From: Geoff Gibbs [REDACTED]
Sent: 12 October 2020 18:52
To: Planning <Planning@arun.gov.uk>; Michael Eastham <Michael.Eastham@arun.gov.uk>
Subject: Planning Application Reference A/76/20/PL Land at Dappers Lane Angmering

84 No. dwellings, public open space, play areas, associated infrastructure & landscaping. This application affects a Right of Way

I **object** to this Planning Application.

I wish to add to my Objection submitted on 6th July 2020.

Date	Drawing No.	Rev.
November 2019	D1260-PL300	C

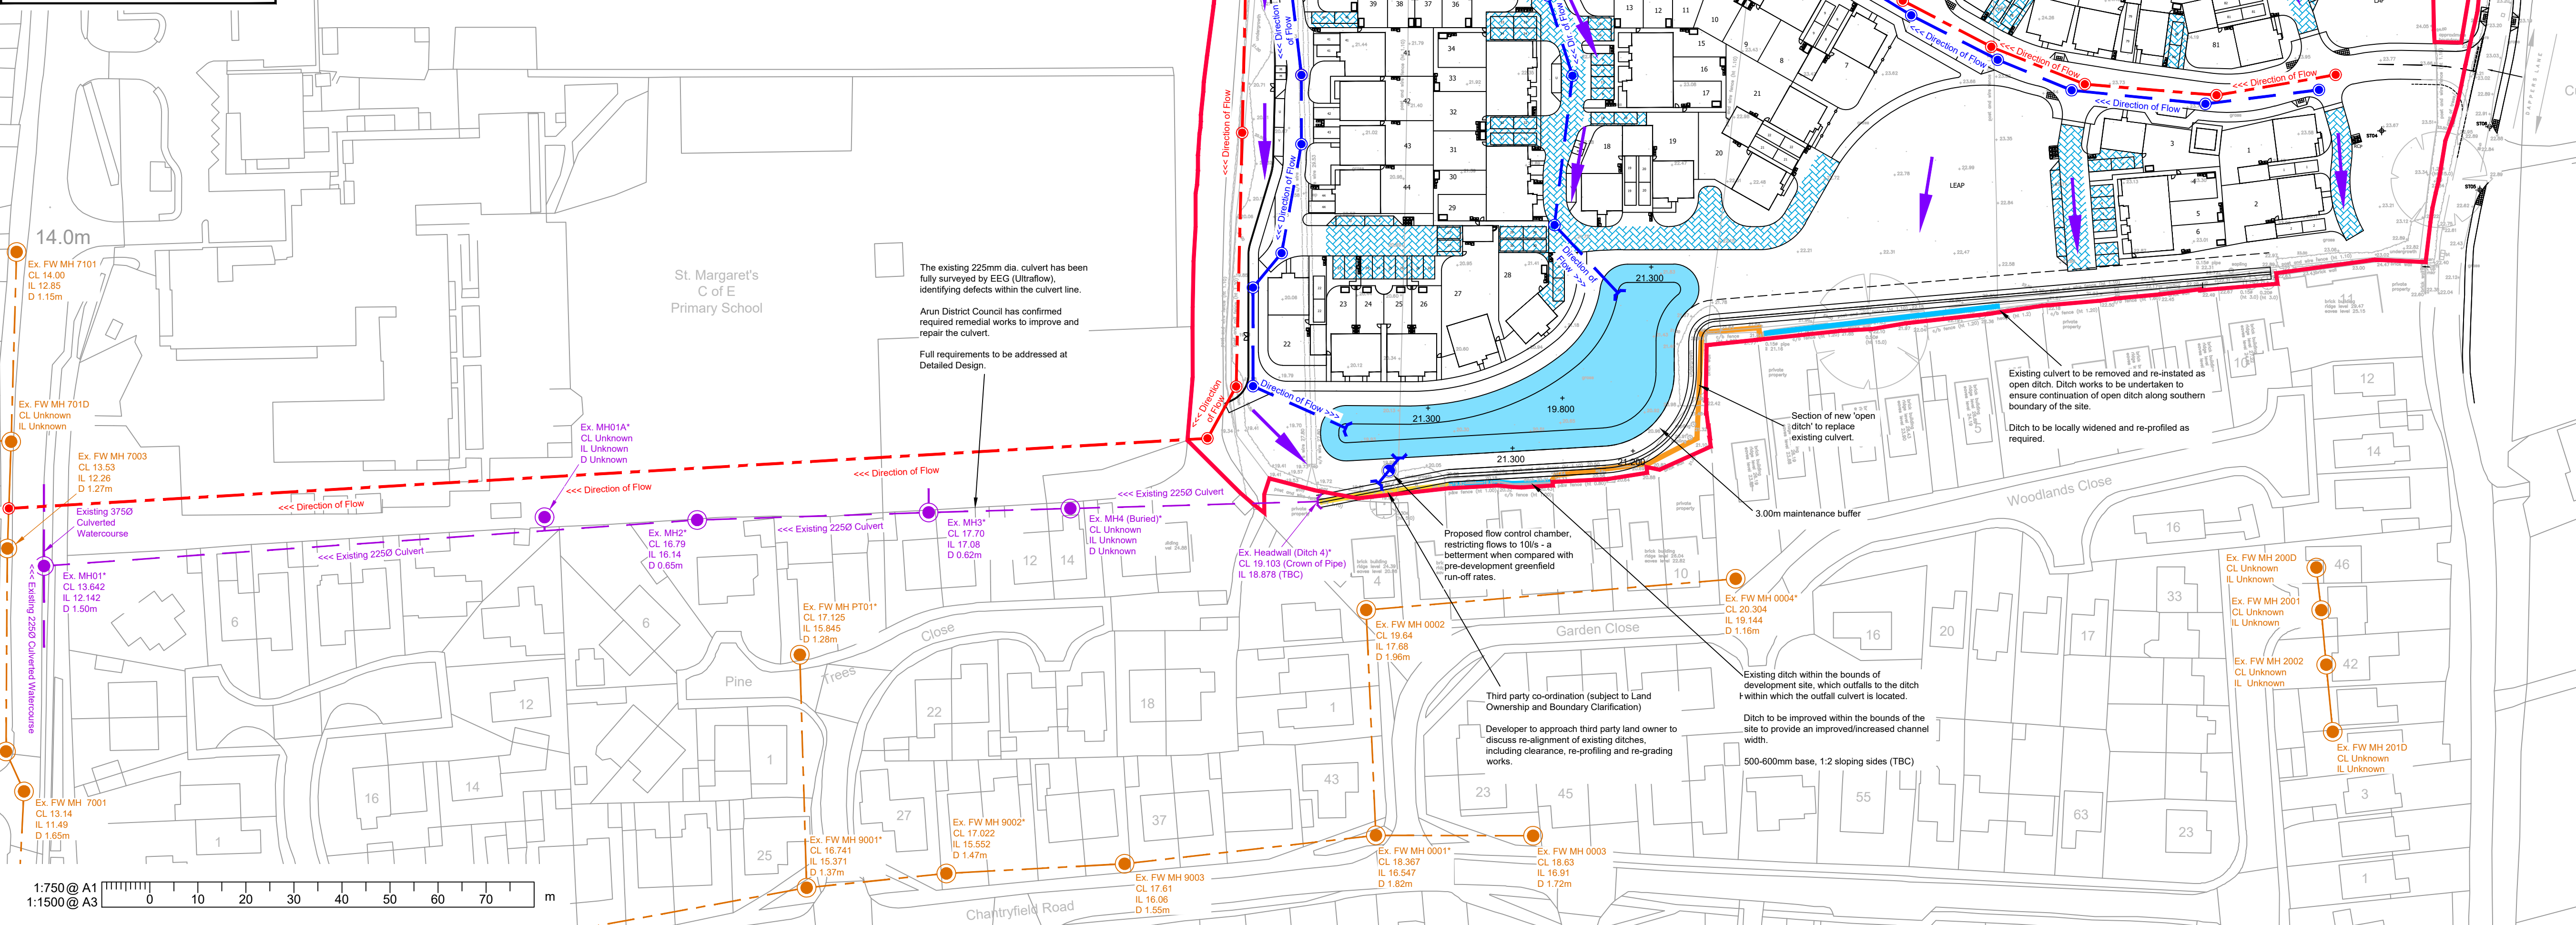
On 28th July 2020, I was pleased to attend a Zoom conference with the Arun Planning Officer and Engineering staff regarding my drainage and flooding concerns. However, if anything, this strengthened my concerns about the poor condition of the existing surface water drainage system described as a culverted ordinary watercourse from the site to Arundel Road and the flooding risks posed to existing residents.

Two options have been proposed.

- To discharge runoff from the site to the existing culverted ordinary watercourse. Because of its location, it could prove a flood risk to others in the future.
- To construct a new ordinary watercourse north of, and parallel to, the existing culvert. It would appear from the documents that this is intended to be constructed as a culvert. The Flood and Water Management Act 2010 made some changes to the Land Drainage Act 1991 and I believe WSCC as the LLFA would be likely to oppose the culverting of this new watercourse.

Clarity is needed as to which option will be proposed. If it is the latter then it needs to be clear whether the LLFA would consent such a construction.

Arun District Council's '*Surface Water Drainage Proposal Checklist*' states at paragraph 12 '*Unless specifically requested by the council's drainage engineers 'Exceedance Flow Route Plans are only required for developments of more than 5 residential properties or more than 0.5 ha of commercial development'*'. Eighty-four proposed dwellings are well in excess of the threshold of five properties requiring an '*Exceedance Flow Route Plan*'. An '*Exceedance Flow Route Plan*' had not been submitted at the time of my original representation and, although three months has passed, we still do not have an '*Exceedance Flow Route Plan*'.

Such an '*Exceedance Flow Route Plan*' is necessary to demonstrate the safety of those in Woodland Close, Garden Close, Pine Trees Close and Furzefield Close.

I believe also, that for the comfort of residents, the Application should have included full details of the drainage system downstream of where it reaches Arundel Road. It is unclear whether it connects with a system that reaches the Black Ditch via Palmer Road or Arundel Road.
